Appeal Decision

Appeal Ref: APP/R5510/W/23/3332009

1 Heatherfold Way, Eastcote, Hillingdon HA5 2LG

- The appeal is made under section 78 of the Town and Country Planning Act 1990 (as amended) against a failure to give notice within the prescribed period of a decision on an application for planning permission.
- The appeal is made by Mr Bakrania against the Council for the London Borough of Hillingdon.
- The application Ref is 66946/APP/2023/2165.
- The development proposed is side extension to existing garage.

21/337/205

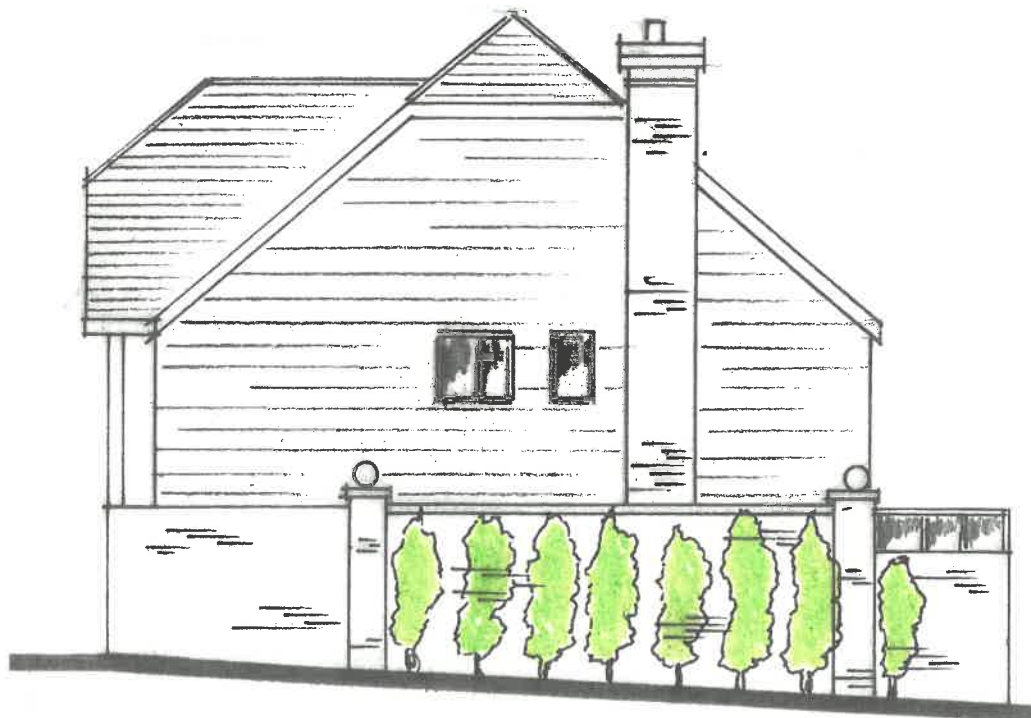
3. I saw on site that the side extension to the garage has already been constructed. However, it included 3 windows in the side elevation fronting Wiltshire Lane, which are not shown on the submitted plans. For the avoidance of doubt, I have considered the appeal on the basis of the development that was originally applied for, as shown on the submitted plans.

9. The side extension has significantly increased the width of the single garage, which is exacerbated by the low, flat roof profile. As a result, while the extended garage does not dominate the appeal property, it does appear disproportionate and is no longer a subordinate addition. Despite using complementary materials, the flat roof of the extended garage, which is not a common feature in the area, and the large blank garage door, jar with the visual richness of the appeal property. As a result, the extended garage appears incongruous and harms the appearance of the appeal property.

18. The specific requirements for garages set out in Table 1: Parking Standards of Appendix C of the Local Plan Part 2 seek to avoid flat roofs, double width doors and long unrelieved walls, especially if they front towards the street. The extended garage would not meet these requirements and would therefore conflict with Policy DMT6 of the Local Plan Part 2 in this regard.

Block Plan

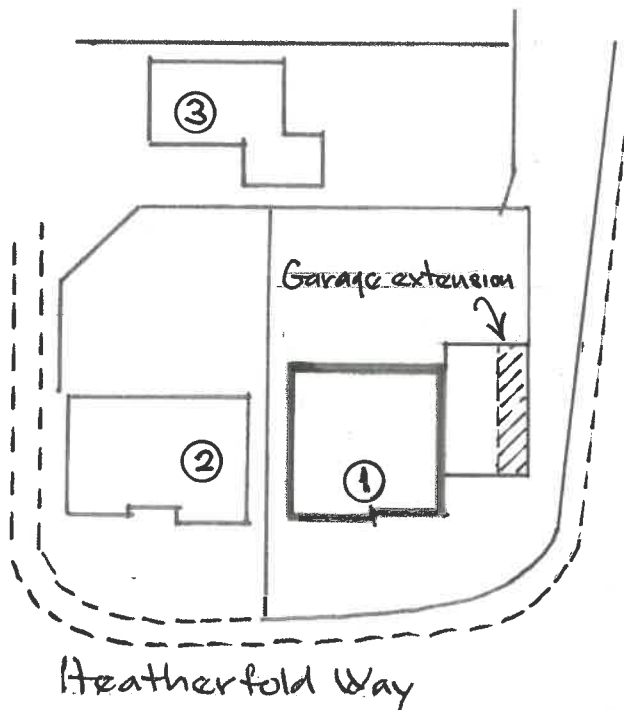
10. Contrary to Policy DMHD1 of the London Borough of Hillingdon Local Plan Part 2 Development Management Policies (2020) (Local Plan Part 2), the extended garage exceeds the return building line of the previous single garage. It is set much closer to the highway than the other houses adjacent to Wiltshire Lane, taking up space that previously consisted of a grass verge, hedging and some small trees. This erodes the sense of spaciousness along this section of Wiltshire Lane.

11. I appreciate that the side extension is partially screened in some views by the existing hedging and trees along Wiltshire Lane. Also, I saw that some new hedging had been planted adjacent to the flank elevation of the extended garage, as shown in the submitted plans. Nonetheless, I cannot be certain that the hedging and trees would remain in their current form. While it may be that it helps soften the proposal, it should not be used as a screen to mitigate otherwise unacceptable development.

14. I understand the Highway Authorities concerns regarding the extended garage encroaching upon the visibility splay from Heatherfold Way onto Wiltshire Avenue. However, given Wiltshire Lane is a no-through road, vehicles leaving Heatherfold Way are unlikely to turn right, which significantly reduces any risk of conflict occurring between vehicles, even at times of the day when there may be more vehicle movements.
